An  
Bord  
Pleanála

## Memorandum ACP-323024-25 – Request for Further Information

**To:** Stephen Rhys Thomas, ADP  
**From:** Peadar McQuaid, PI  
**Re:** 323024-25  
**Date:** 18<sup>th</sup> December 2025

Galway County Council is seeking approval from An Coimisiun to undertake proposed works to raise the elevation levels of local tertiary road (L-52214) at Cuan Na Loinge, Ceantar na nOileán, Co Galway. The length of road to be raised is approximately 200 metres. The maximum increase of road elevation will be of 1.0 metre above the existing road level, with natural rock armour embankments and natural stone parapet walls on each sides together with associated drainage, water services, fencing and signage. The subject site is proximate to Kilkieran Bay and Islands Special Area of Conservation (SAC) (Site Code: 002111).

**PROPOSED SITE LAYOUT PLAN
 SAC EXTENTS**
 SCALE 1:500

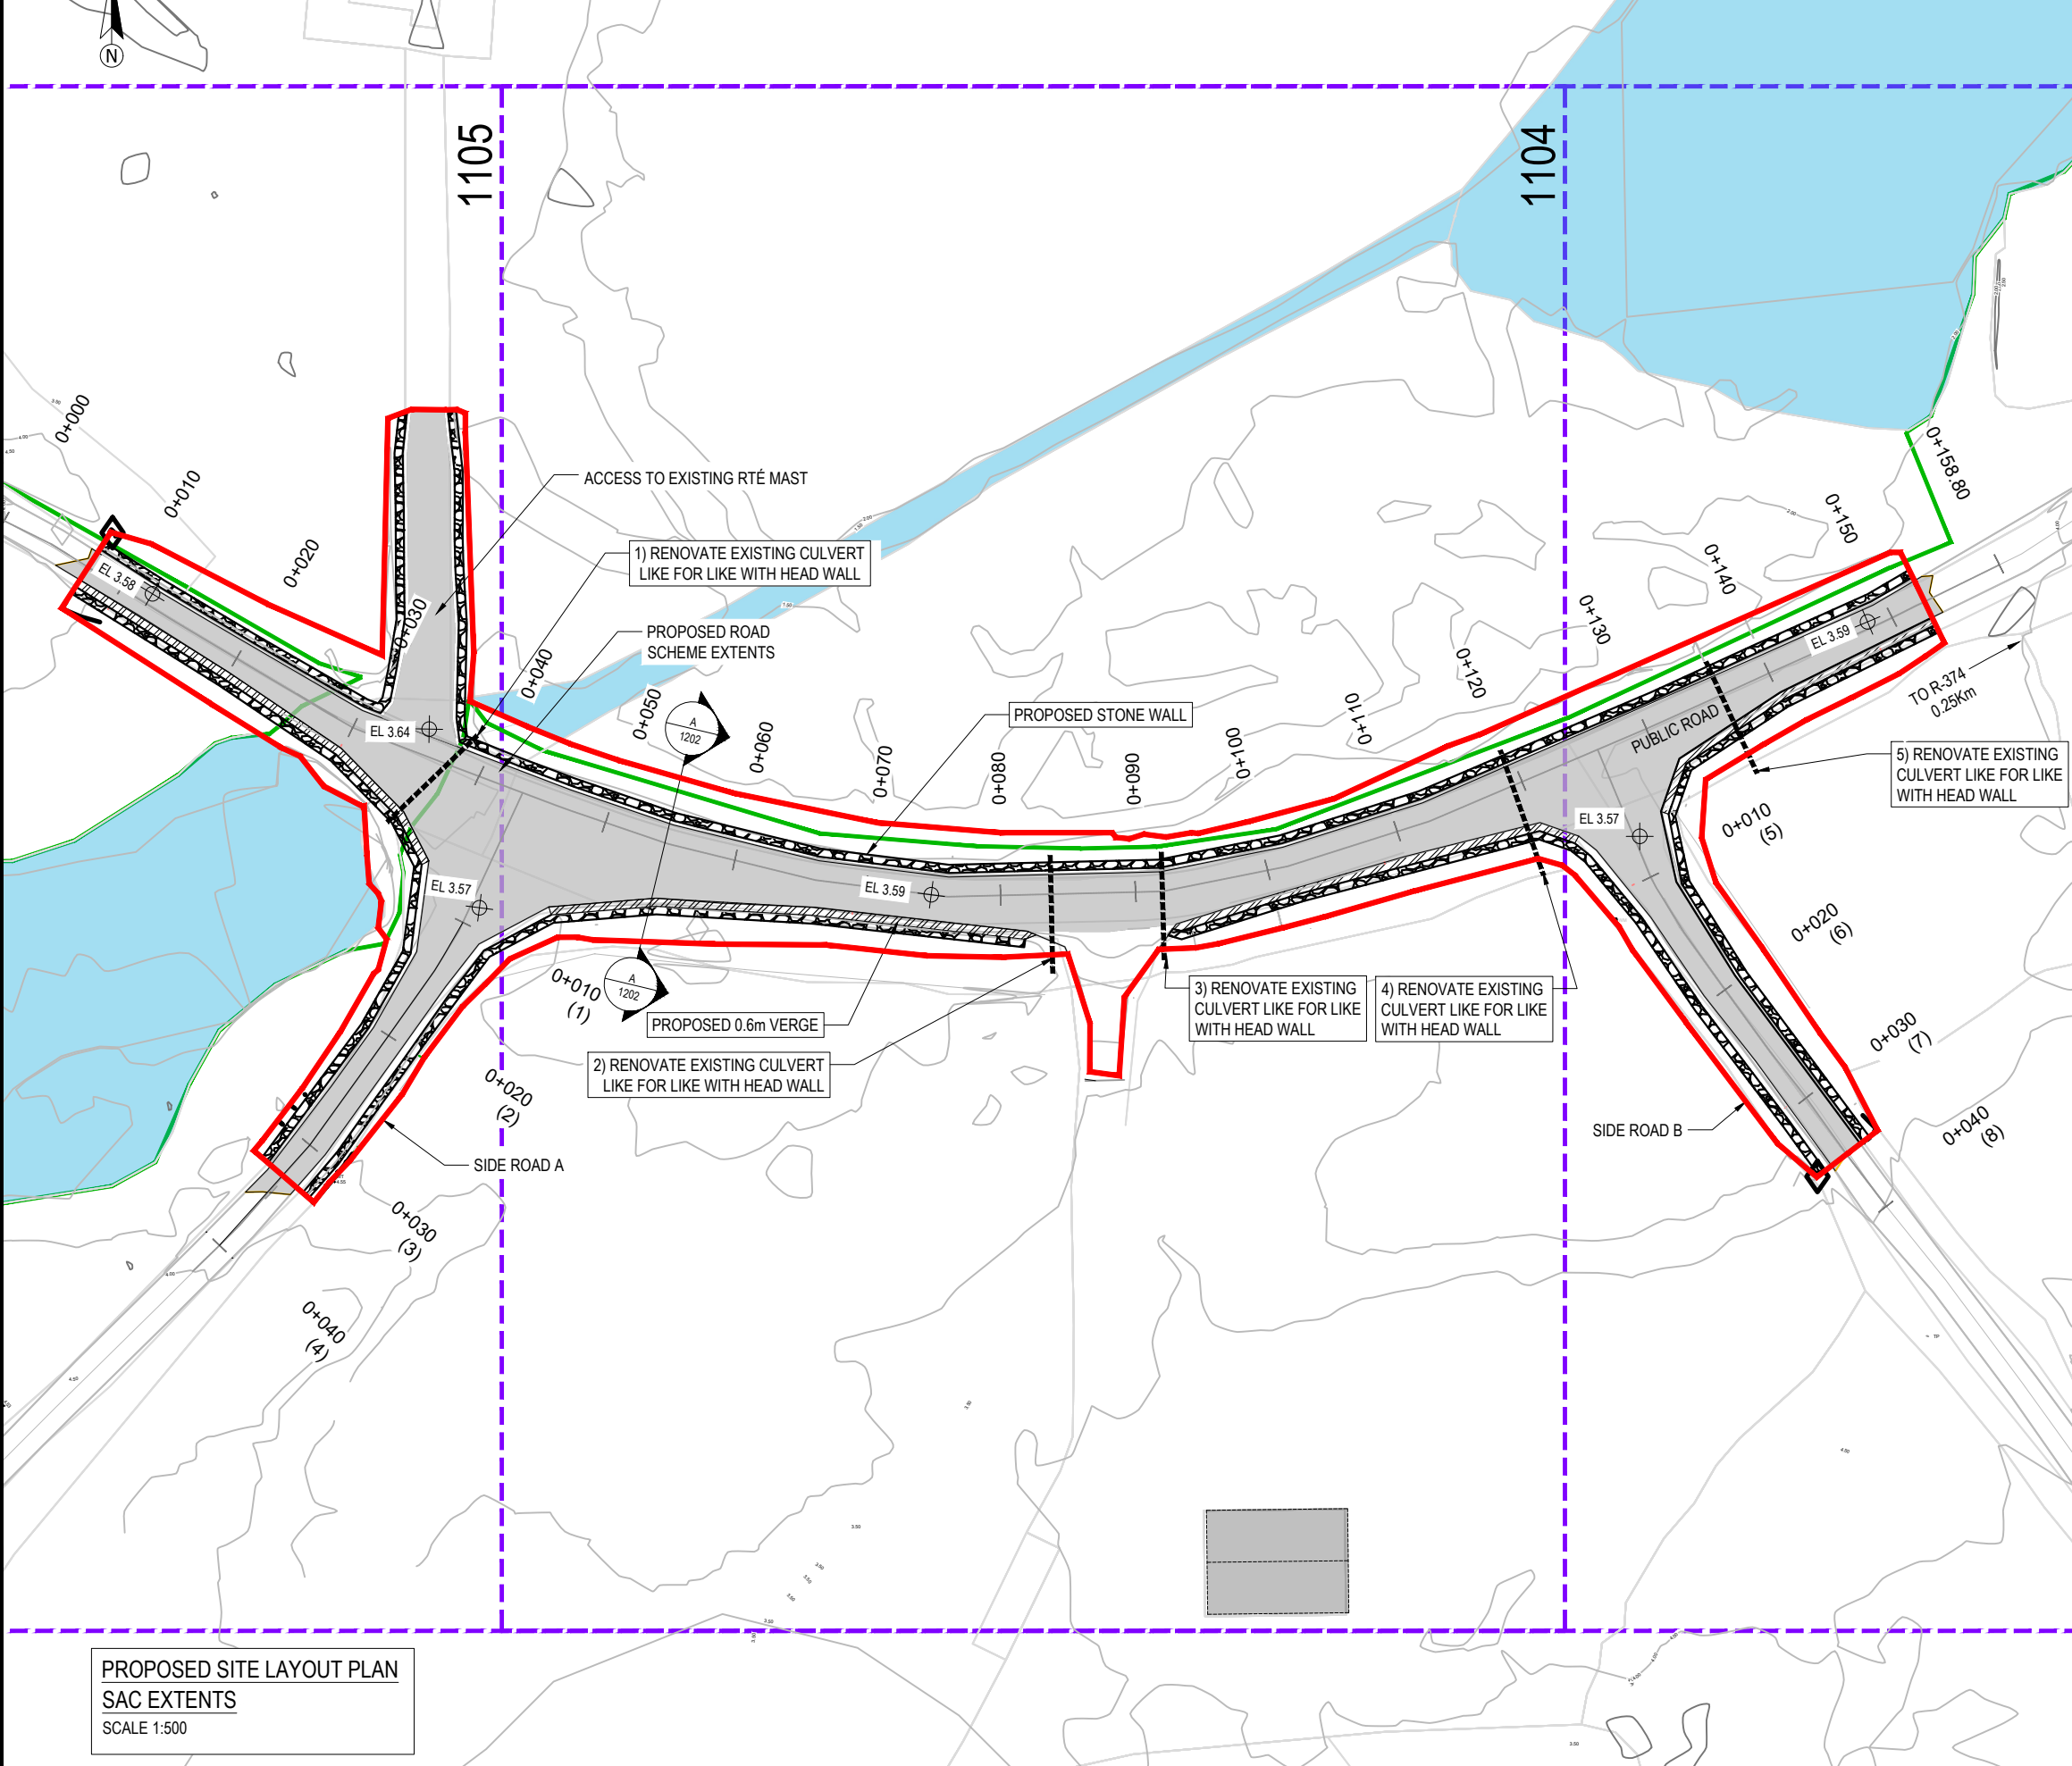
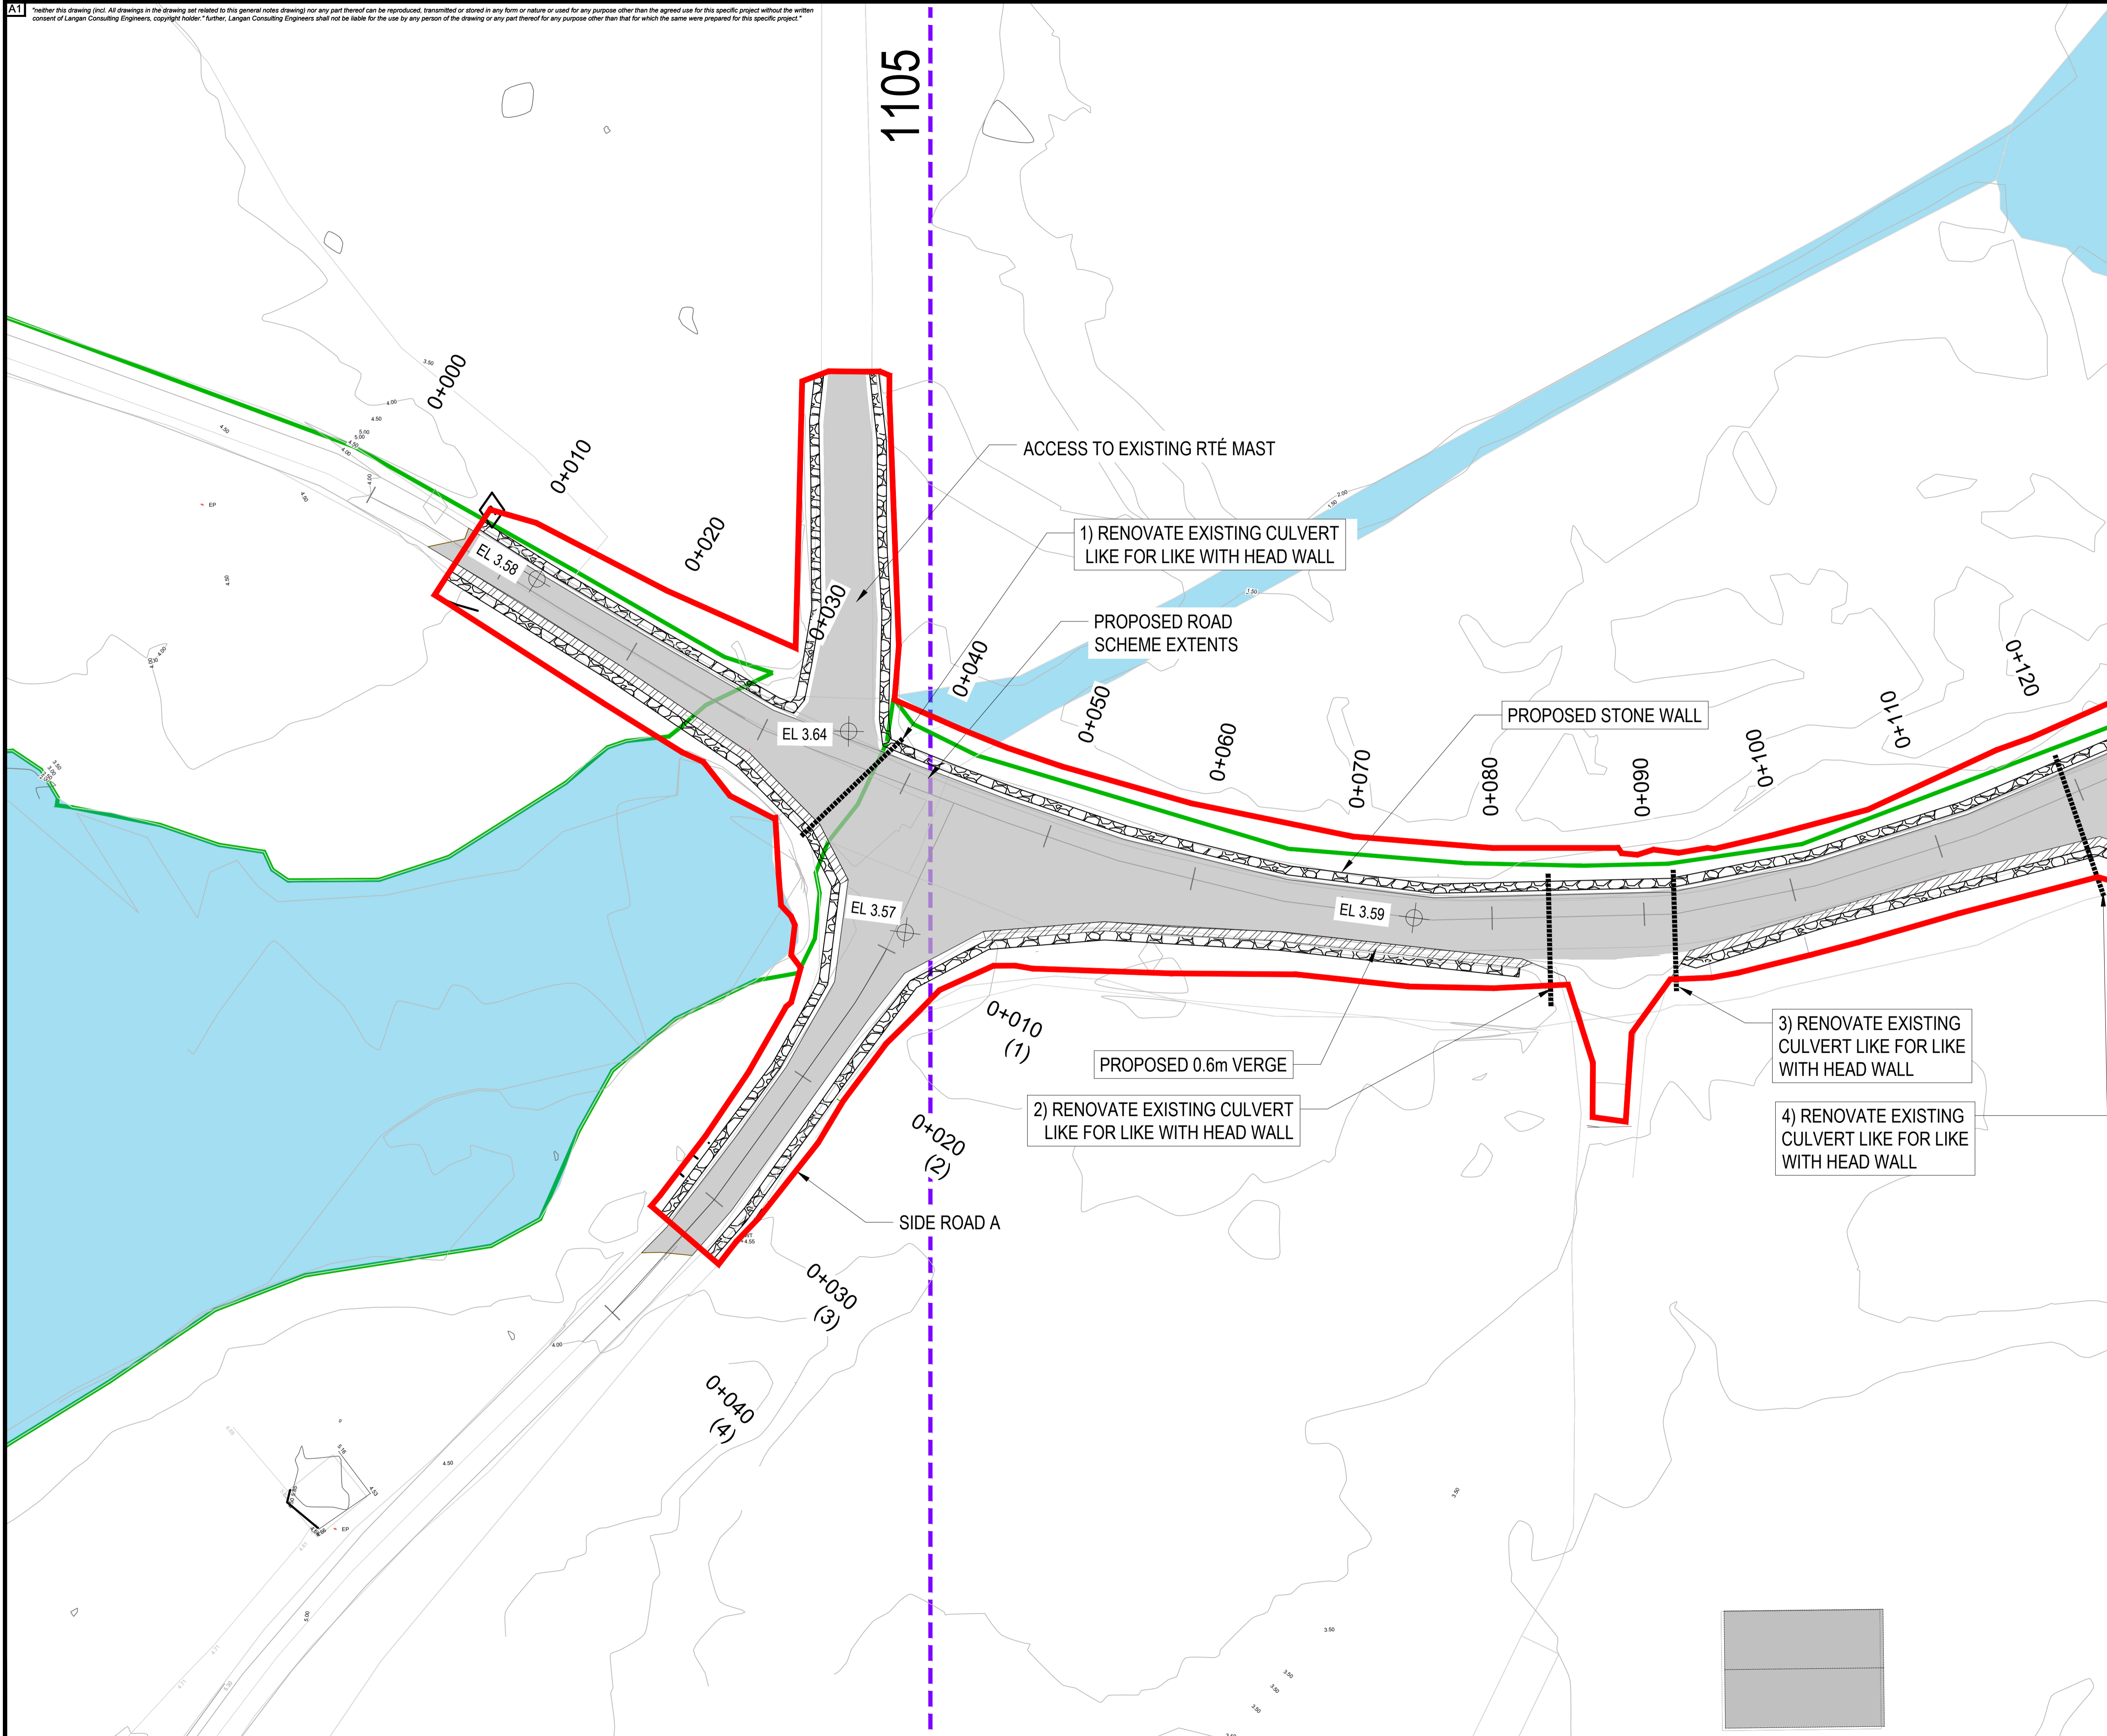
Conflicting information is presented within the Environmental Constraints Report and the NIS regarding the location of the proposed works. Based on the submitted drawings it would appear that the proposed works would encroach into the Kilkieran Bay and Islands SAC. However, this needs to be clarified by the applicant.

- iii. Habitats providing a supporting function to the annex habitat.
  - iv. Habitats of biodiversity value beyond the Natura designation(s).
2. Detailed drawings (1:200 scale) showing the footprint of the proposed works, the SAC boundary and confirmed Annex I habitats/non-Annex I habitats within the application site boundary.
